ENG-SF21021-R3-CDs.pdf Markup Summary

RETREAT AT TIMBERIDGE FILING NO. 2
CONSTRUCTION PLANS
 GRADING & EROSION CONTROL PLAN

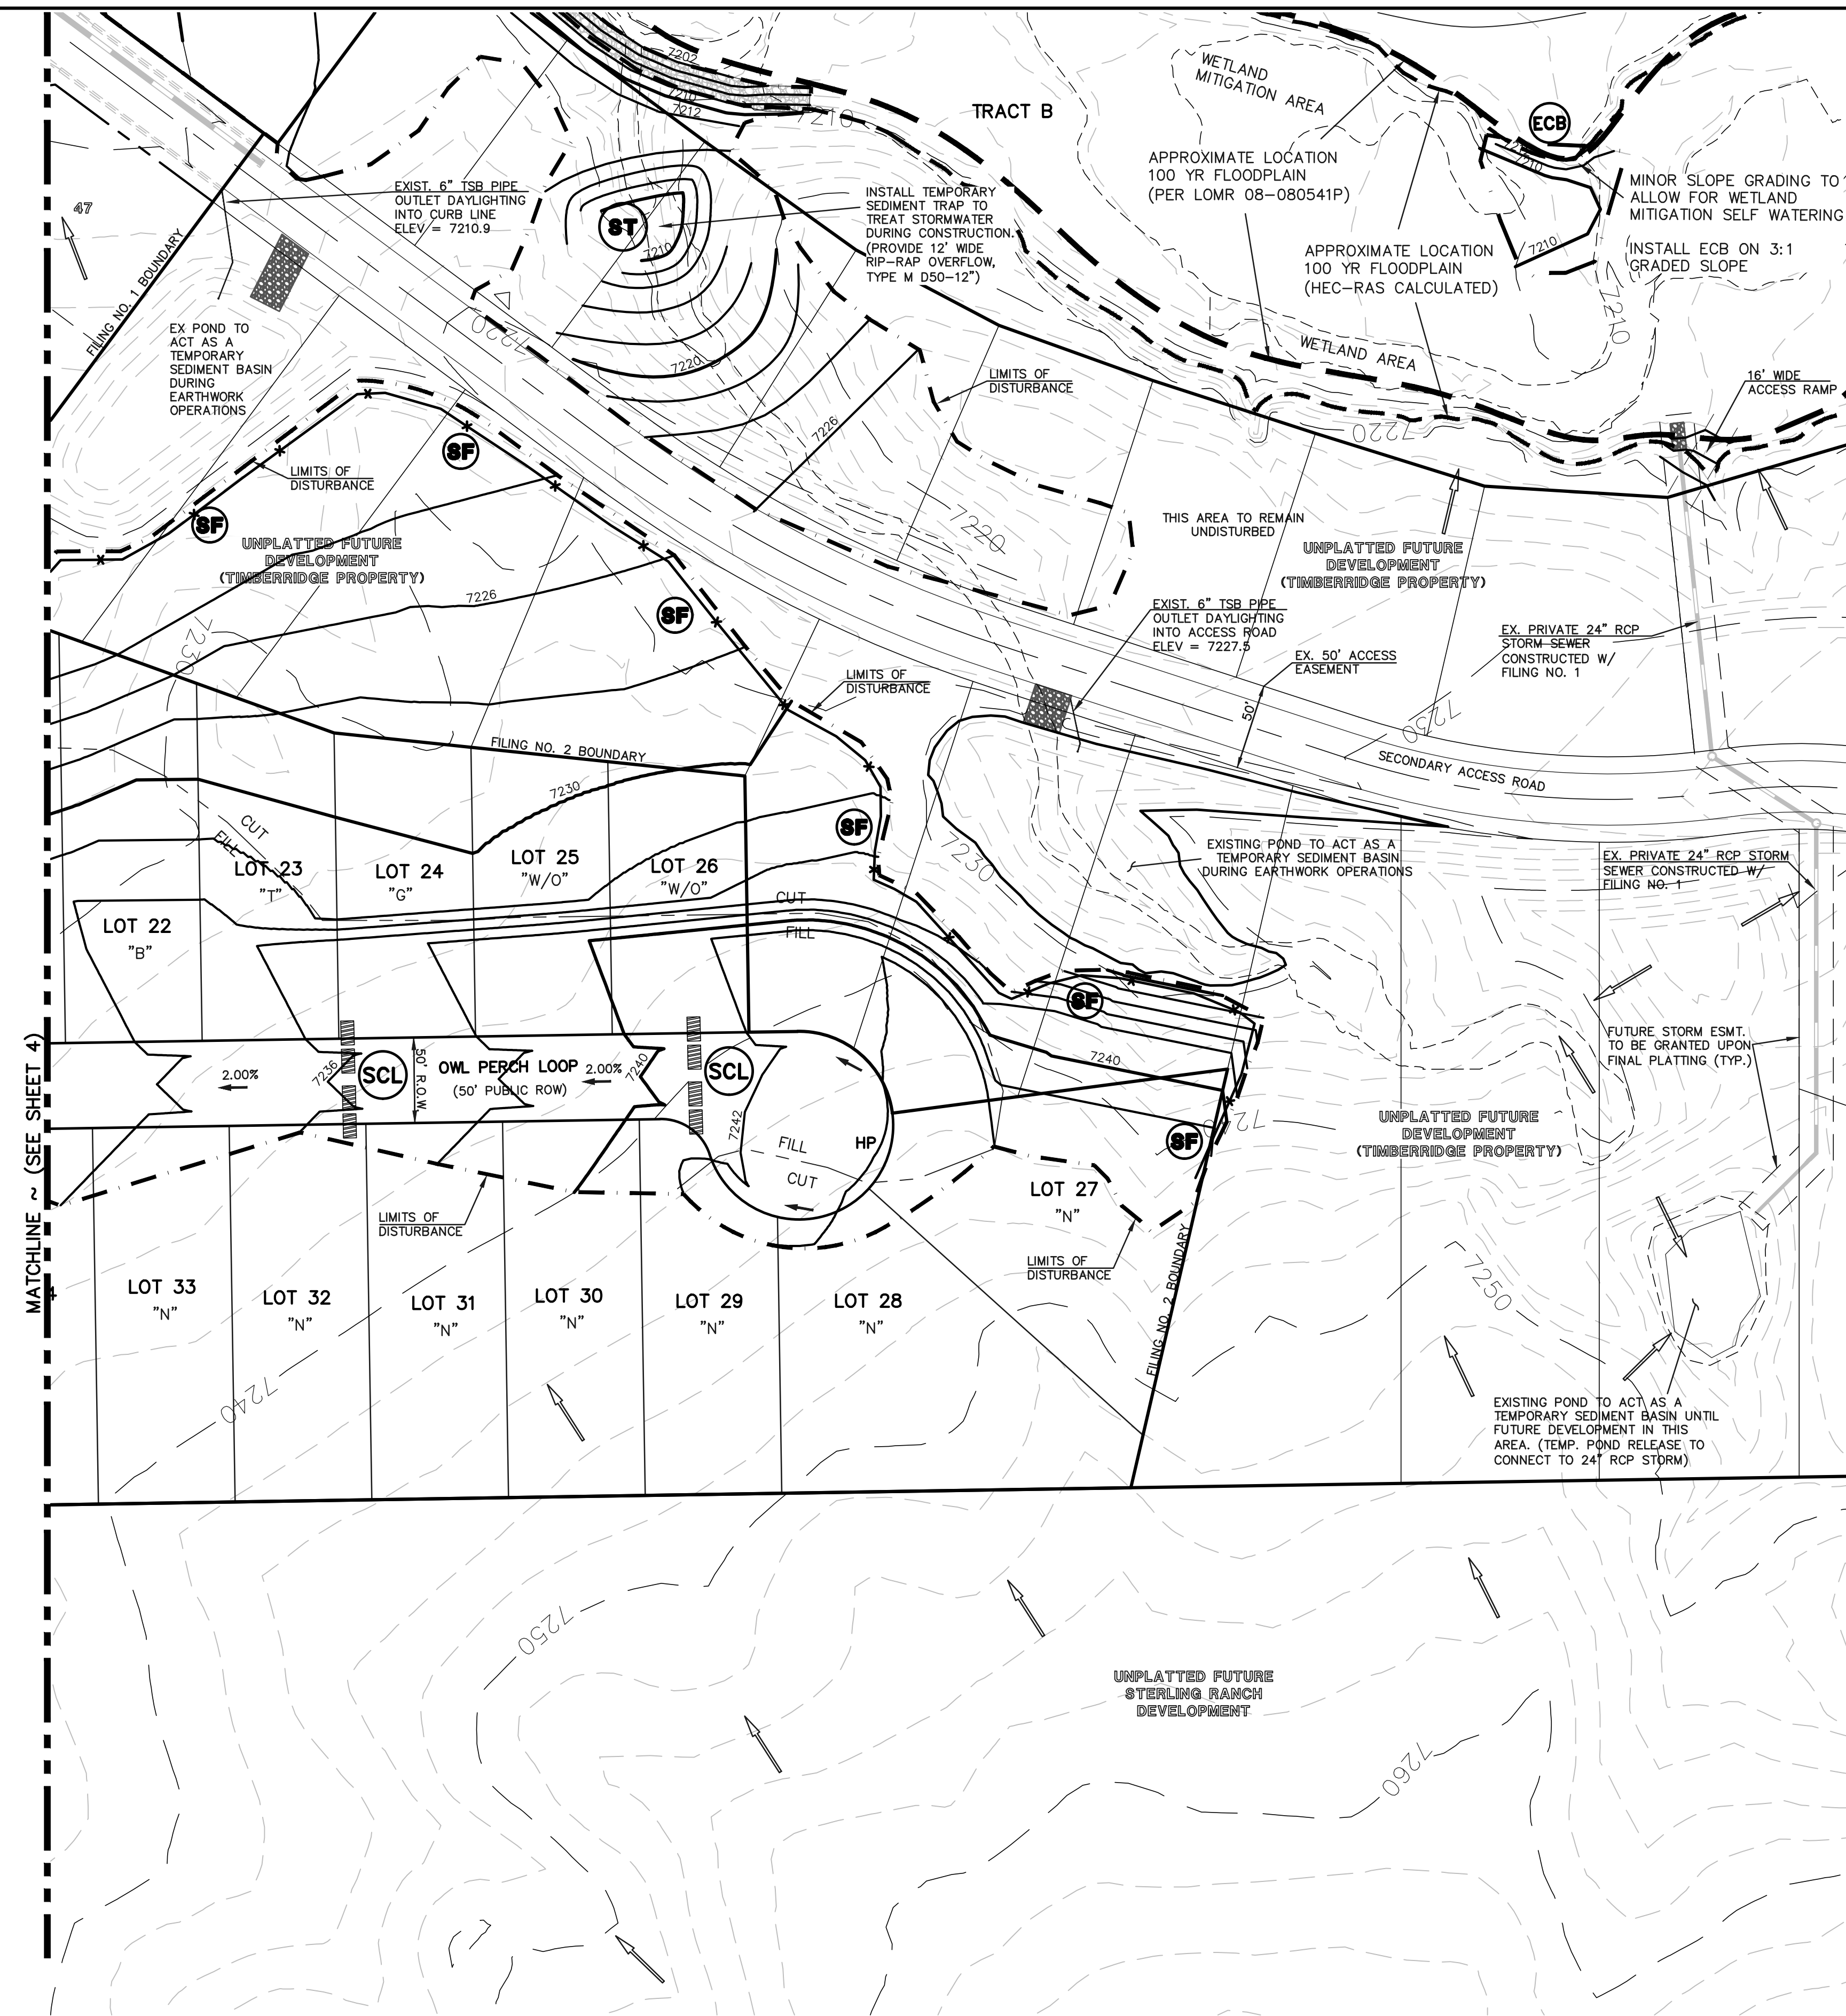
Show where the temporary and permanent outlet pipes will release flows (into an inlet?). Curbline appears to be 5' higher than the pond bottom.

DESIGNED BY PRA SCALE DATE 02-25-21
DRAWN BY PRA (H) 1" = 100' SHEET 3 OF 24
CHECKED BY (V) 1" = N/A JOB NO. 1185.20

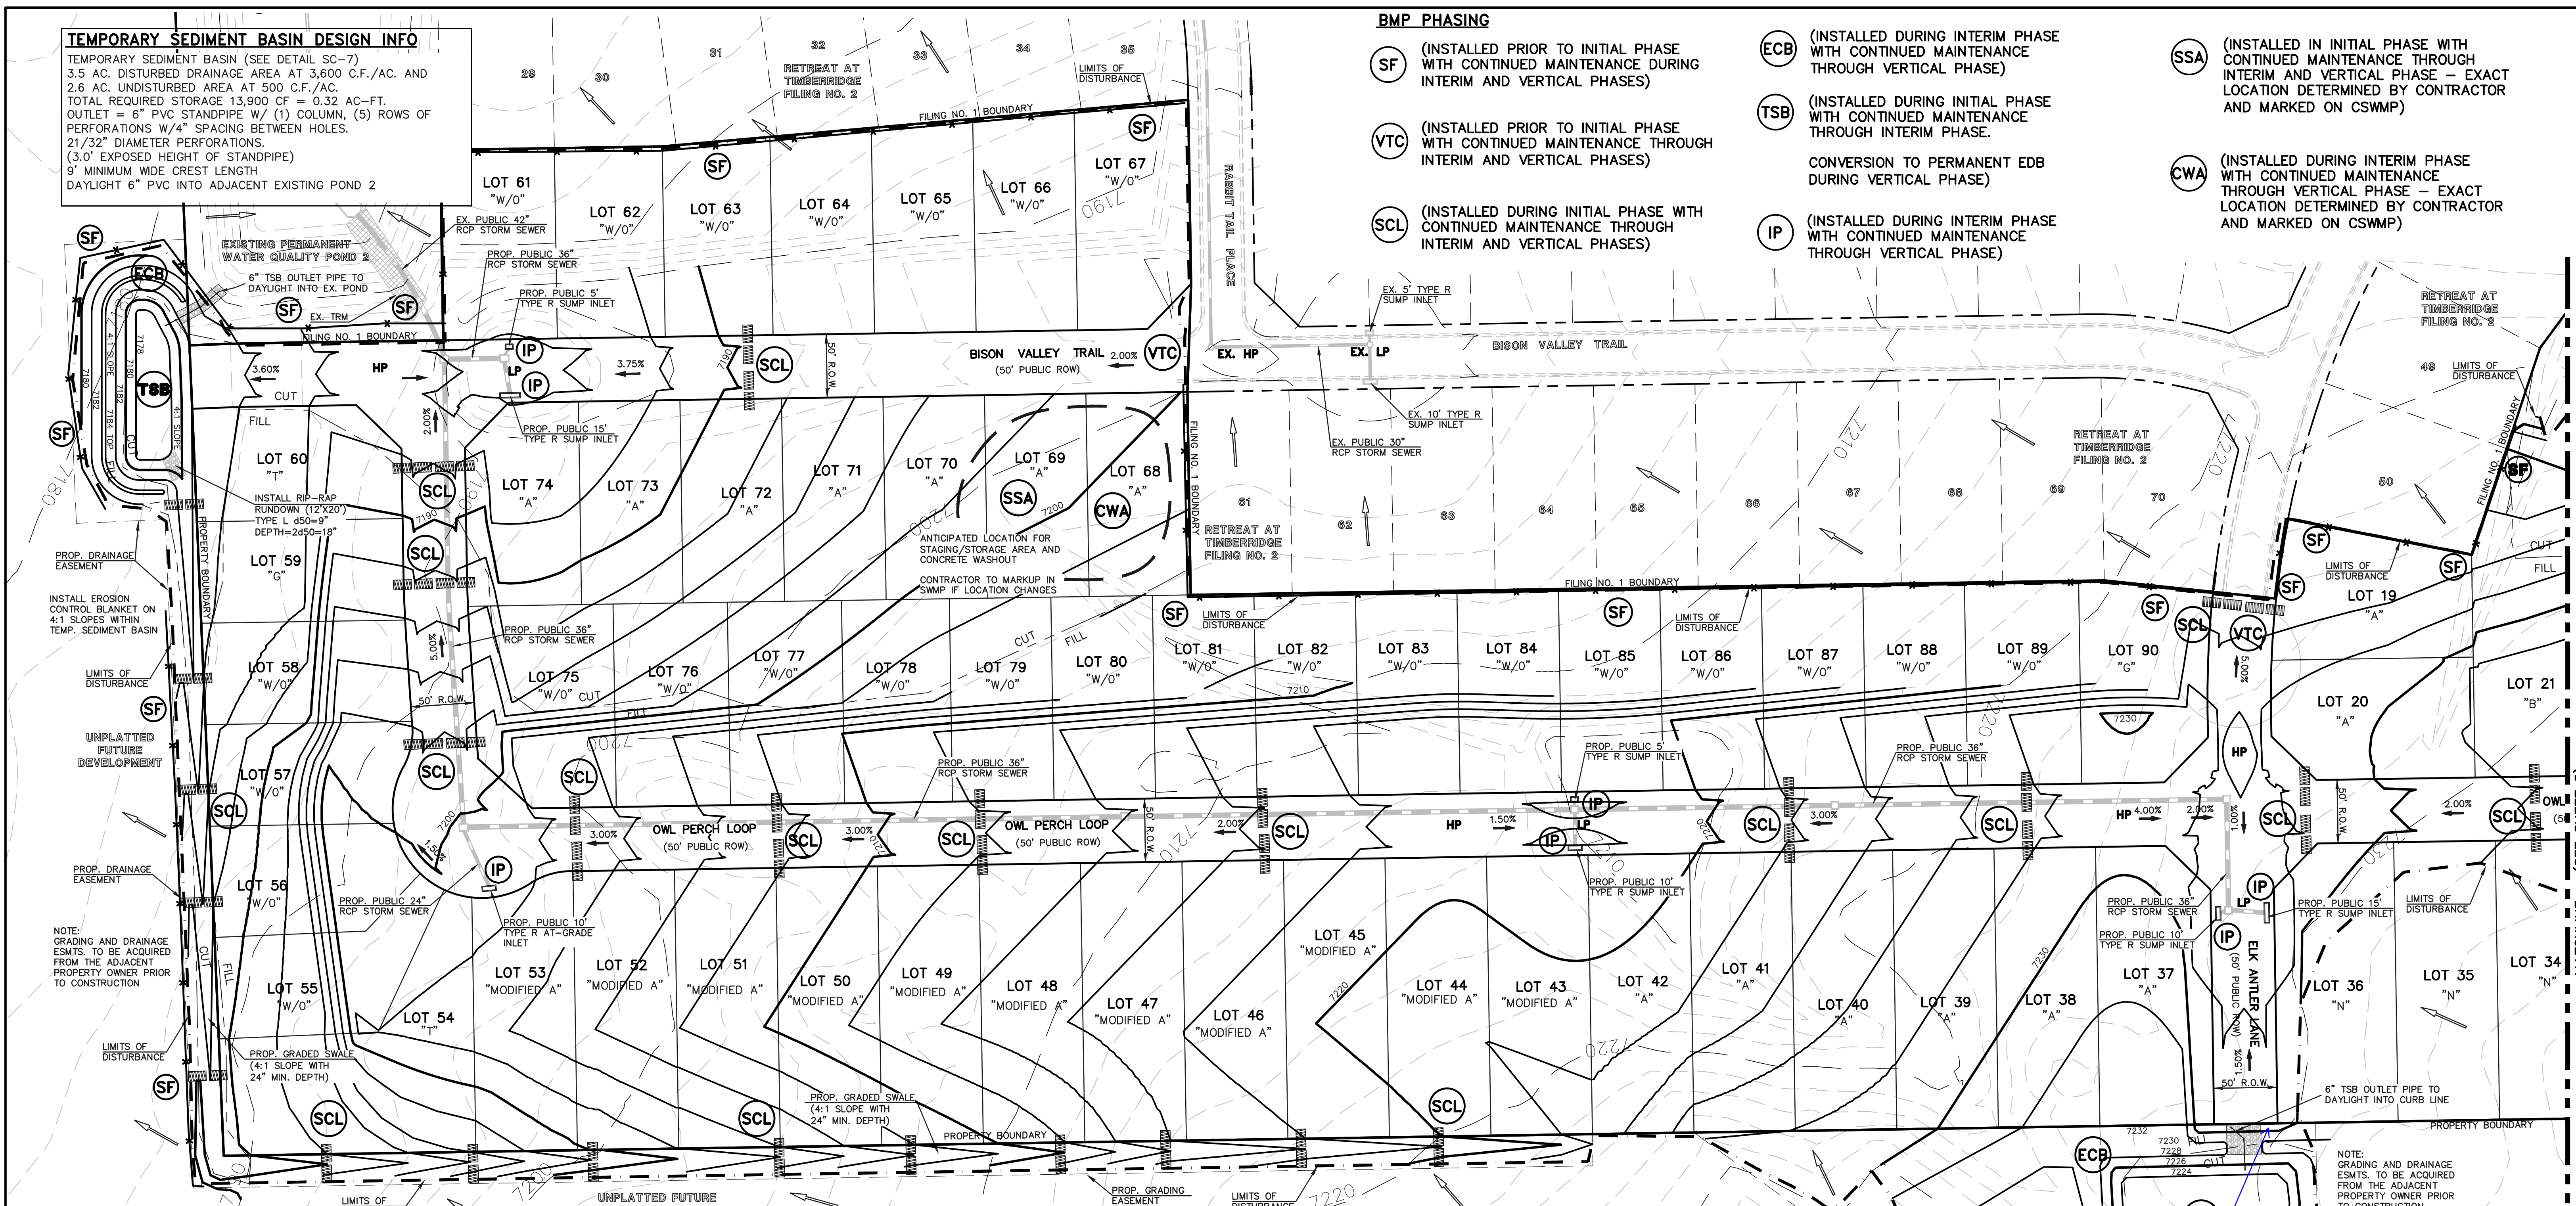
Show all Runoff Reduction RPA areas in drainage easement or no build easement (see Drainage Report for additional information). unresolved.

Provide details of temporary sediment basin including riser pipe perforation sizing, number of rows, required volume, location of outlet and spillway, and tributary area to the sediment basin.

This can be a temporary sediment trap since its treating such a small area.
